The Planning Inspectorate
National Infrastructure Planning
Temple Quay House
2 the Square
Bristol
BS1 6PN

Our ref: WX/2019/133441/01-L13

Your ref: TRO40011

**METROWEST PHASE 1 DEVELOPMENT CONSENT ORDER APPLICATION
EXAMINATION DEADLINE 6 – RESPONSE TO HEARING ACTION POINTS
ARISING FROM ISSUE SPECIFIC HEARING 4 REGARDING THE DRAFT
DEVELOPMENT CONSENT ORDER (DDCO) AND ISSUE SPECIFIC HEARING
5 REGARDING ENVIRONMENTAL MATTERS**

Drawing: **PORTISHEAD STATION CAR PARK LAYOUT, LANDSCAPING AND NEW BOULEVARD AND ACCESS PLAN SHEET 2 OF 3**

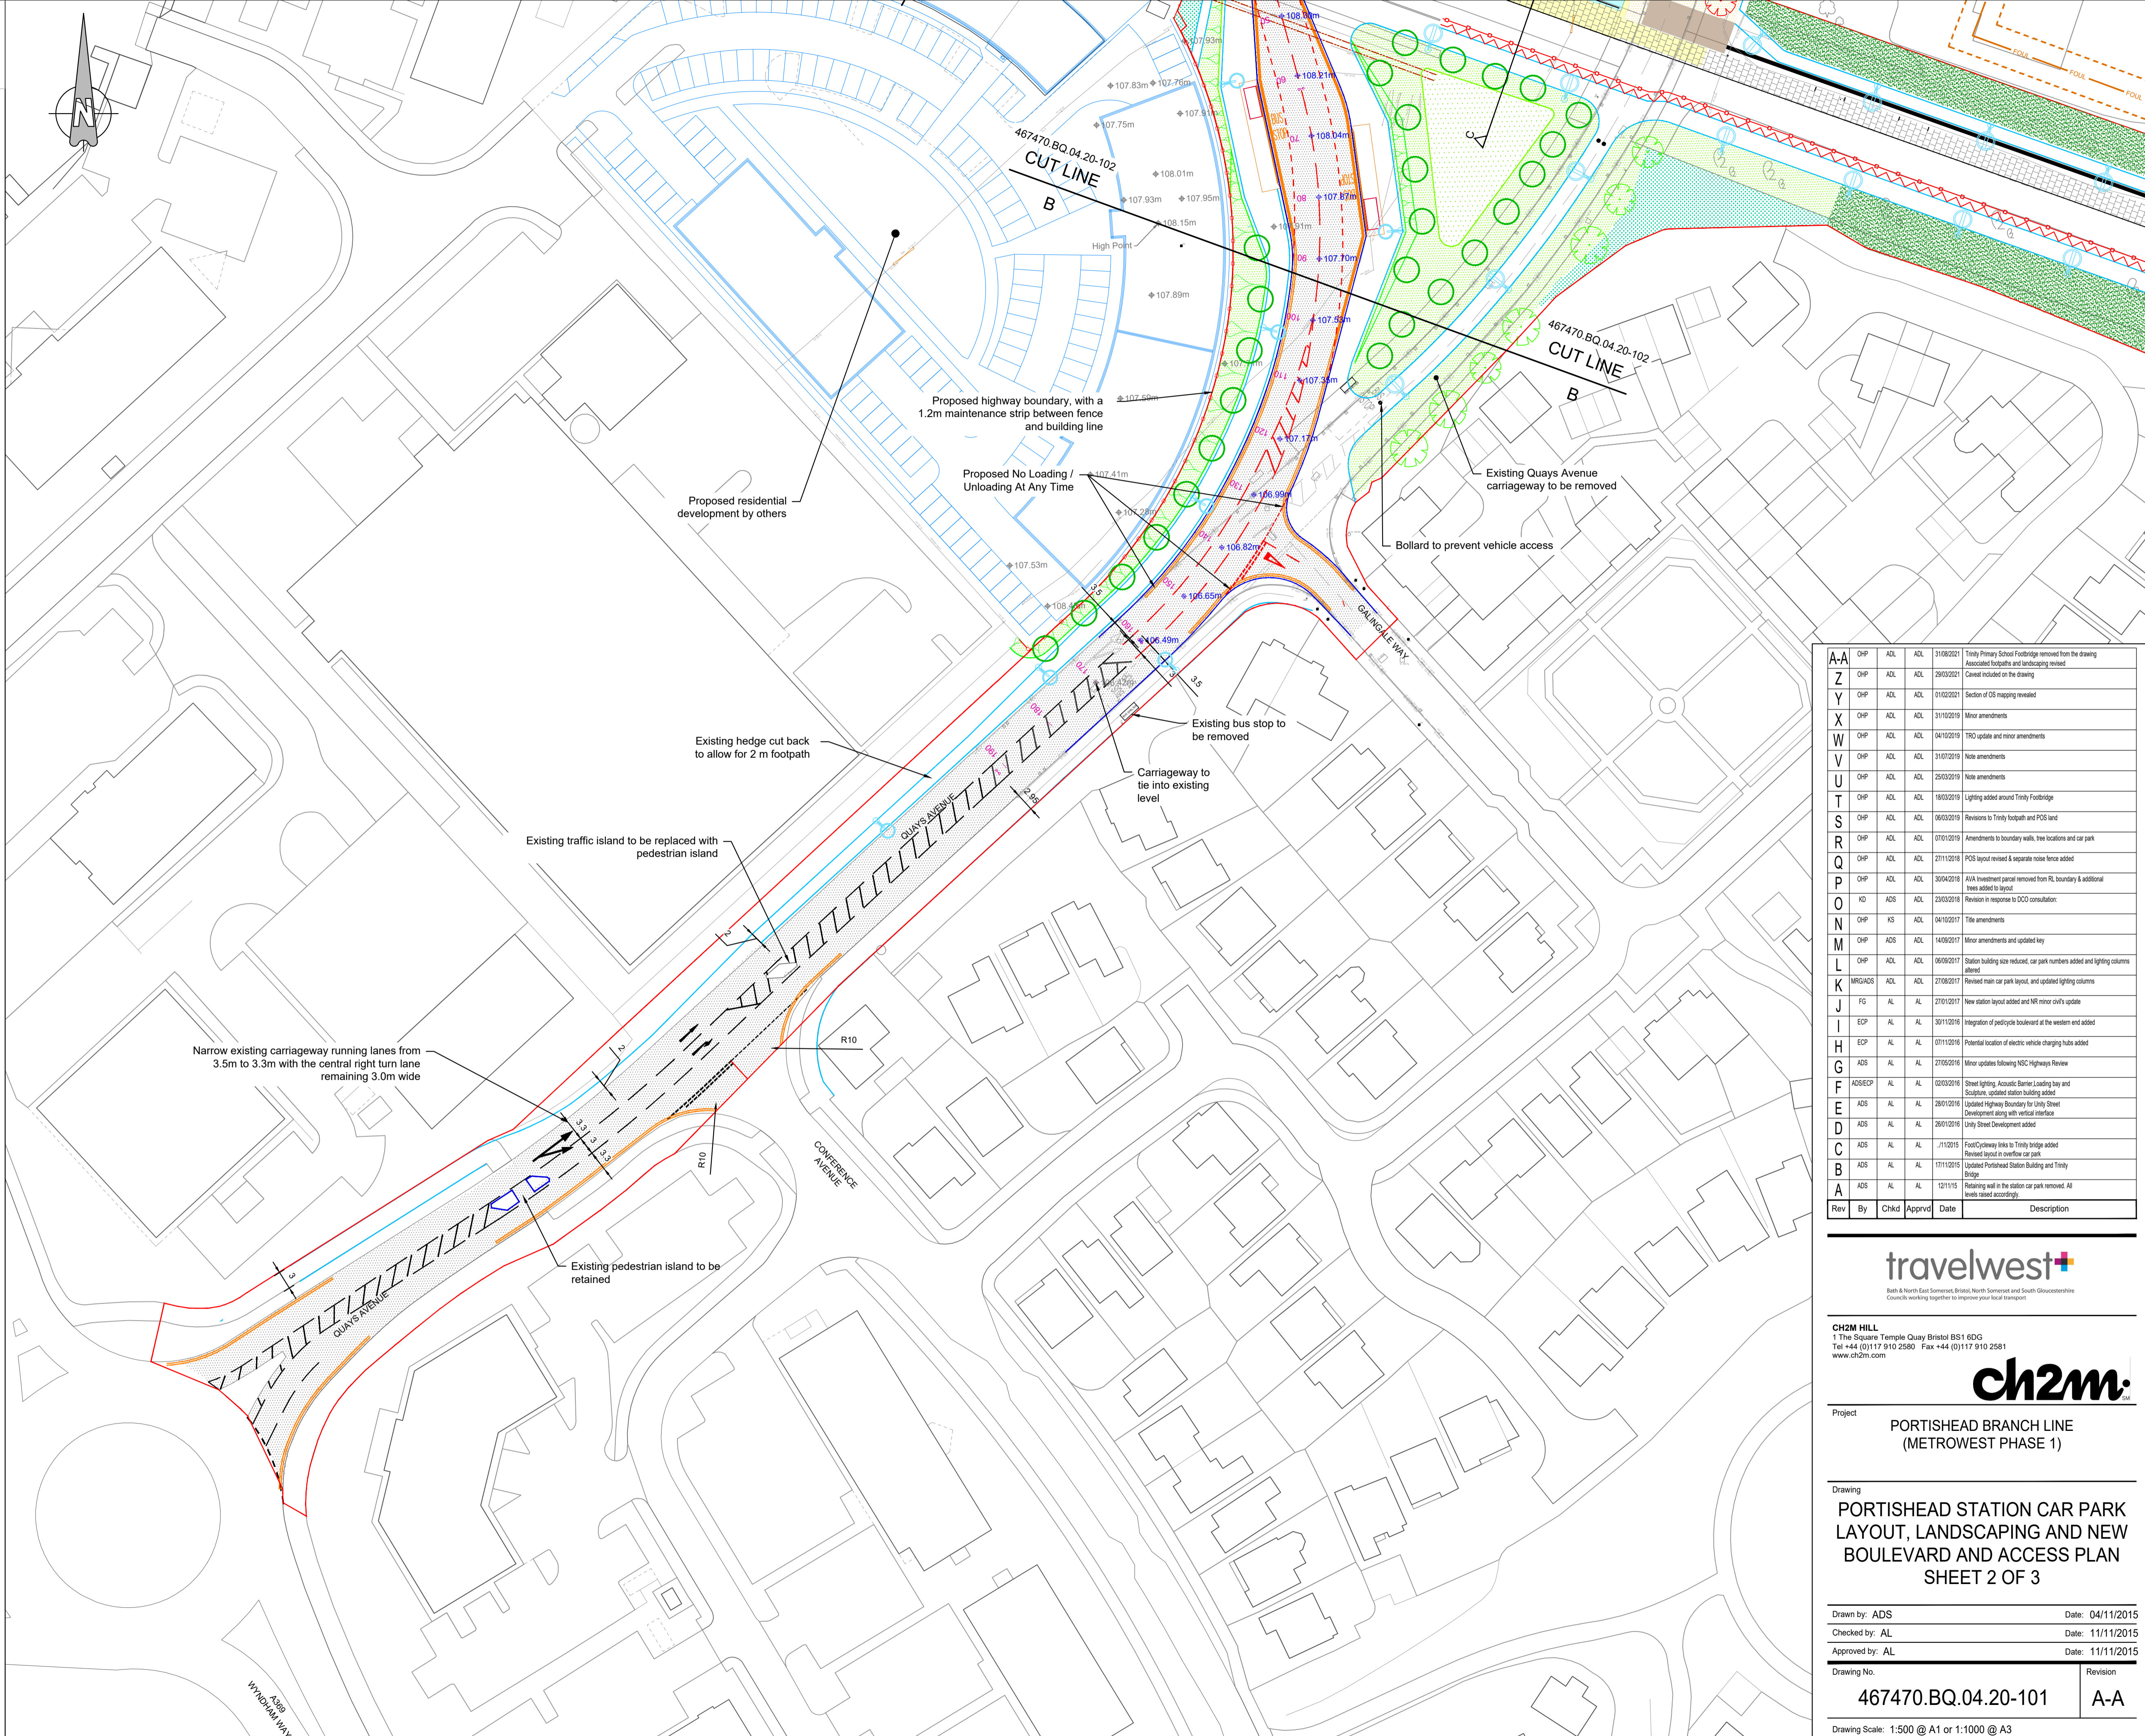
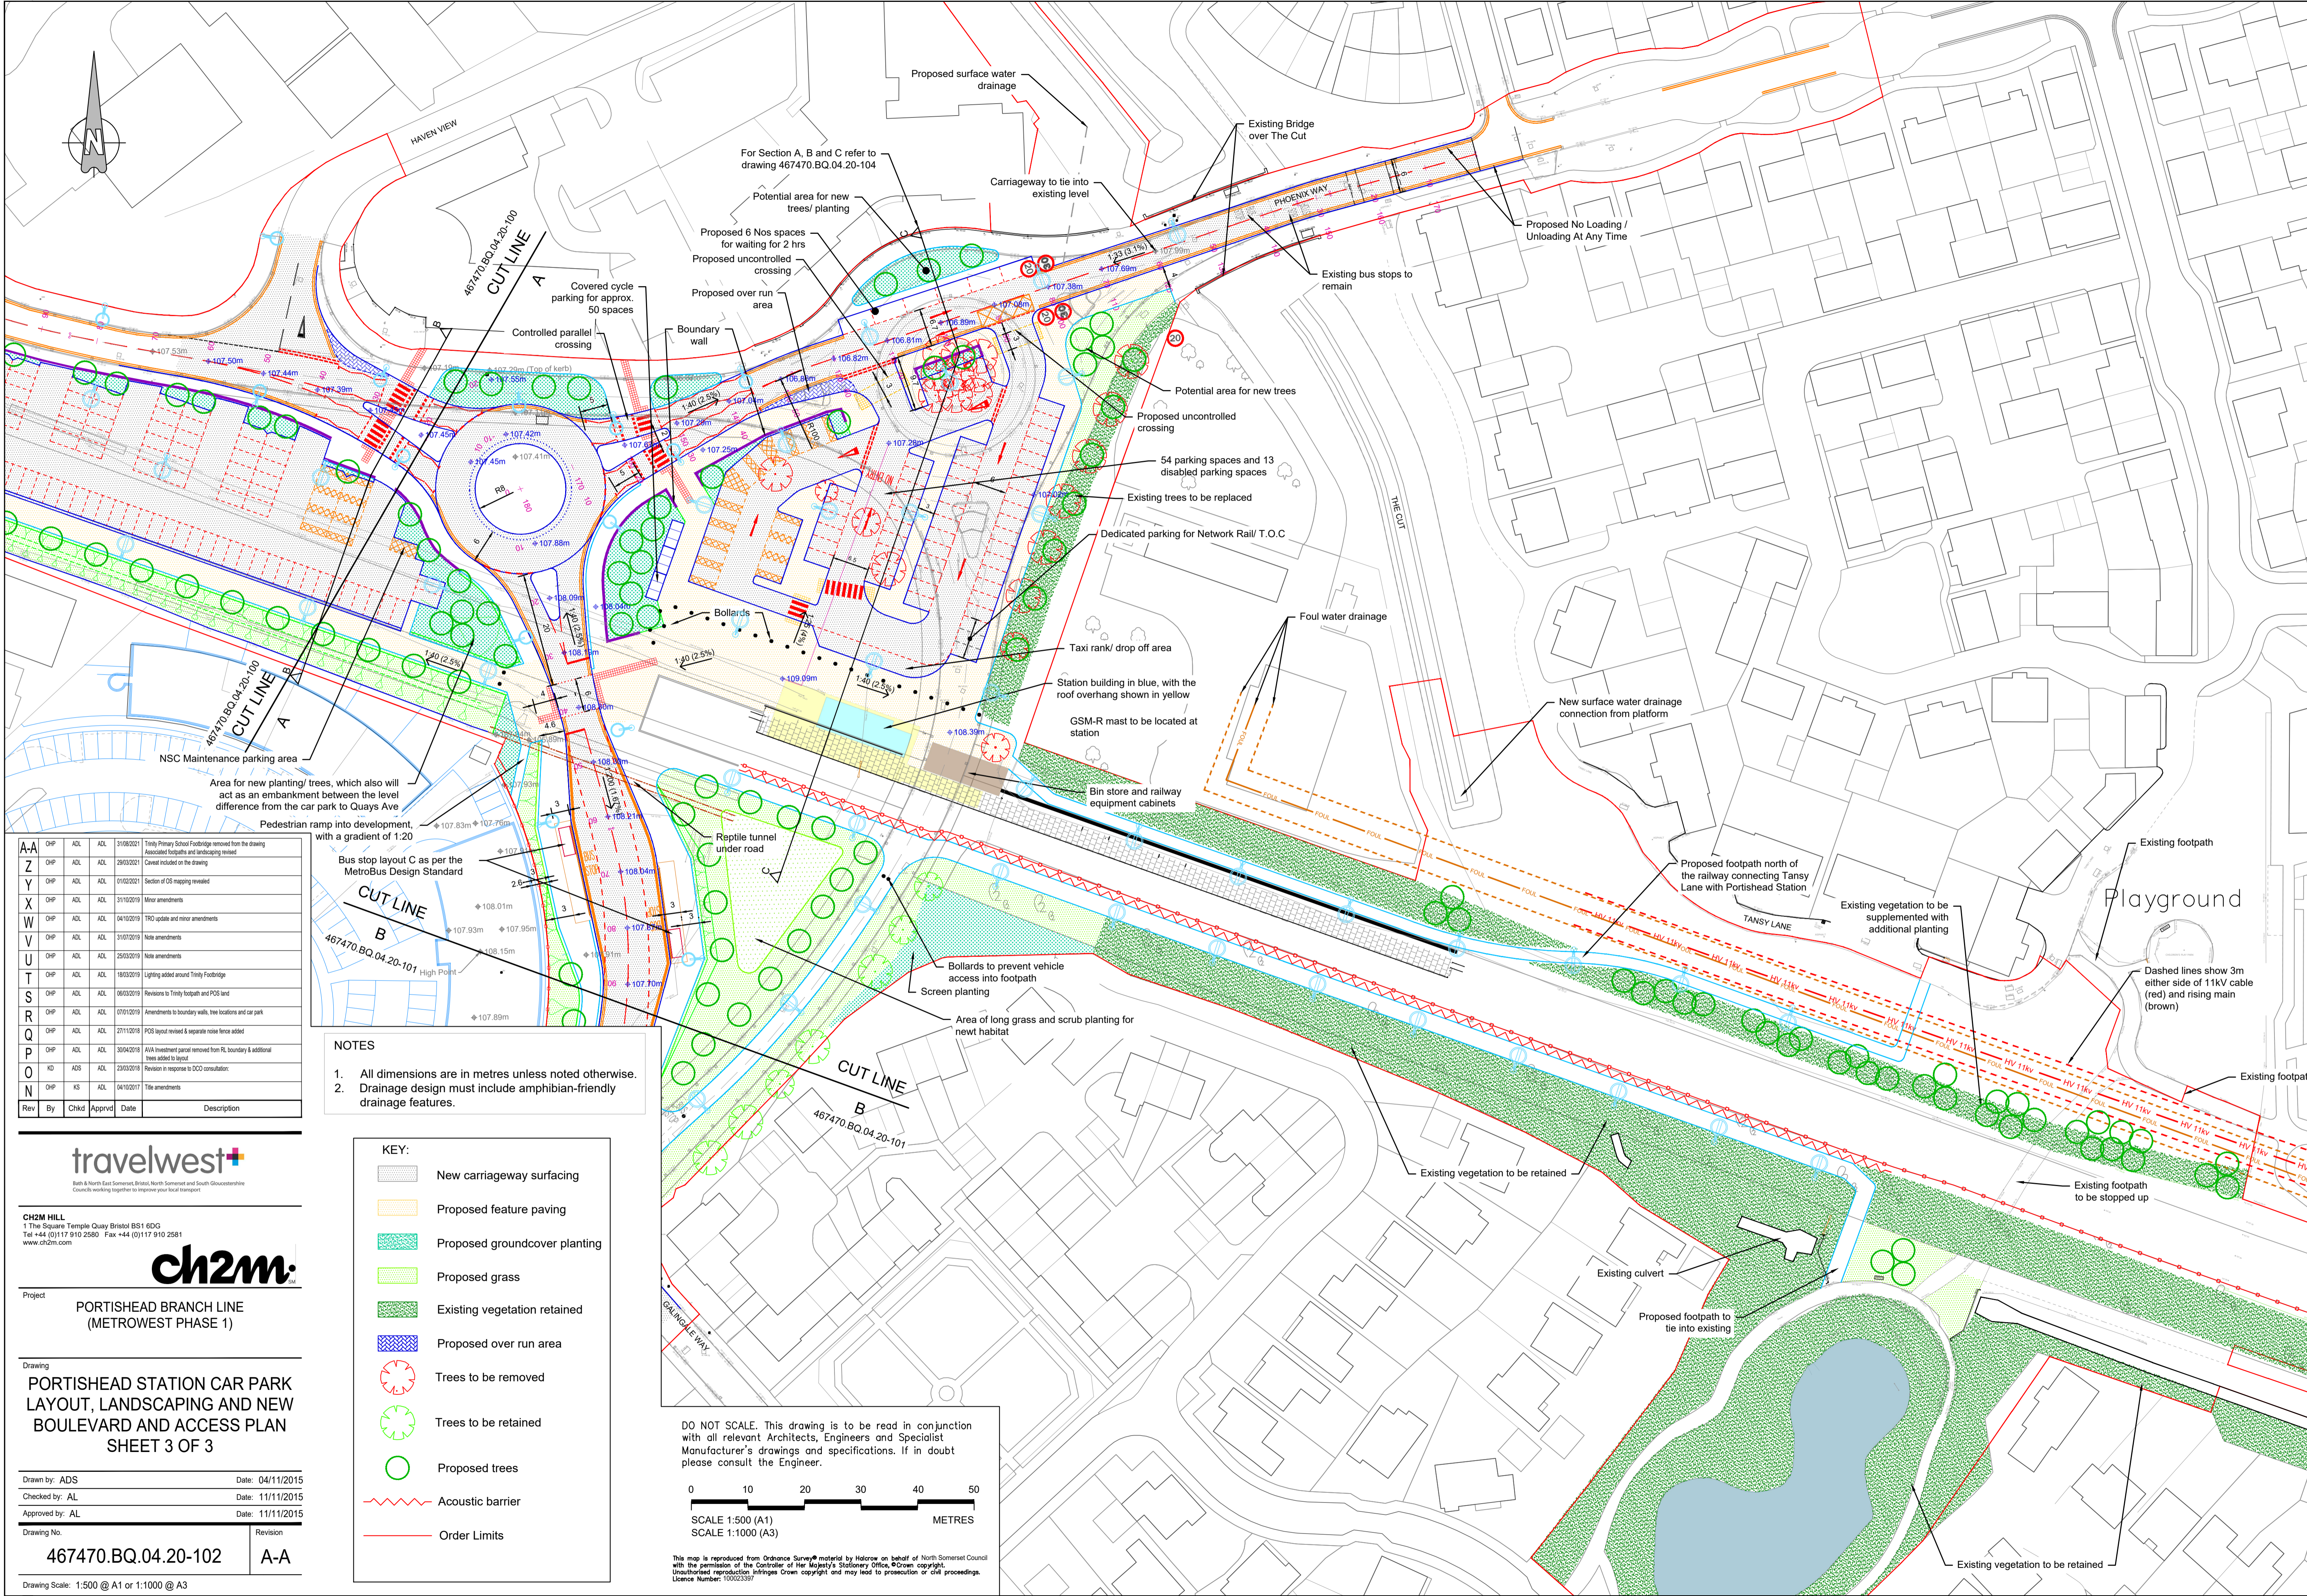
The Agency must advise that a Flood Risk Assessment (FRA) is required for Portishead Station, as it would be for any normal planning application in flood zone 2 and/or flood zone 3. This is required to establish the flood risk and detail how the development and its users will remain safe from the risk of flooding over its lifetime e.g. raised finished floor levels, flood resilience measures, safe refuge, evacuation route etc. A Flood Emergency and Evacuation Plan may be required, as part of the FRA.
